Planning Application Ref: AW/240/21/T

Location: 48 Fish Lane, Aldwick, PO21 3AH

Description of works: Crown reduction of 1no. maple tree to height approx. 10m and spread approx. 8m

48 Fish Ln, Bognor Regis PO21 3AH

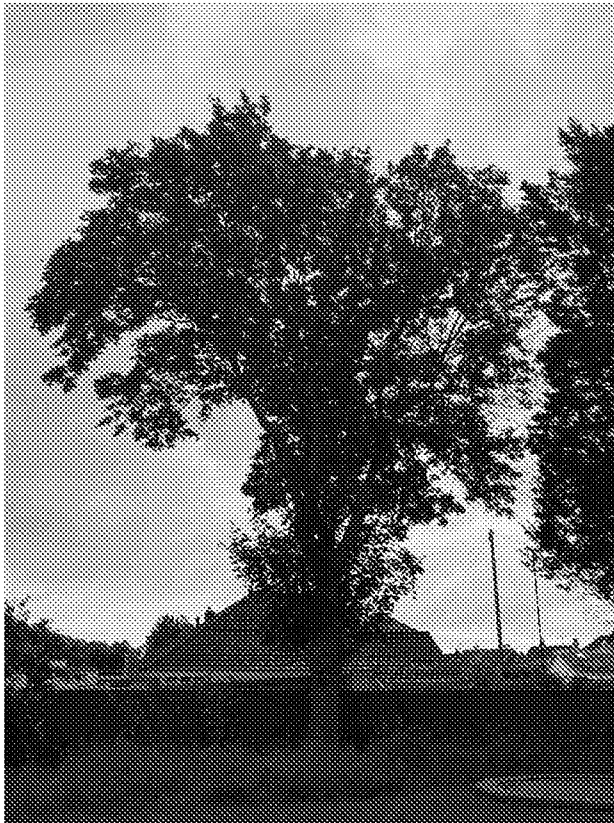
- Outwardly and from a distance (roadside) this tree appears to be in a fair physiological state. It has a relatively unmodified upper crown and is visually impressive. It is visible from numerous properties and to users of the public highway (footway and carriageway).
- Recent removal of dead (and possibly back into live tissue) branches may have initiated the low-level epicormic growth response.
- Whole crown reduction is proposed; to restore vigour and promote new growth. If the tree can sustain such a large volume loss of its primary branch network – new growth would almost exclusively have to arise from dormant buds, irrevocably altering its form.

- This tree requires careful management that respects its age and vulnerability to environmental changes and disease progression. Whatever pathogen or condition is responsible for the physiological stress evident; heavy pruning is going to place further demands on its energy reserve.
- Whole *crown reduction* pruning has not been justified on arboricultural grounds. The proposal would be likely to result in harm to the health and vitality of the tree with large pruning wounds being formed as well as undermining its visual amenity value and impact in the landscape.

- I recommend **REFUSAL** for this application.
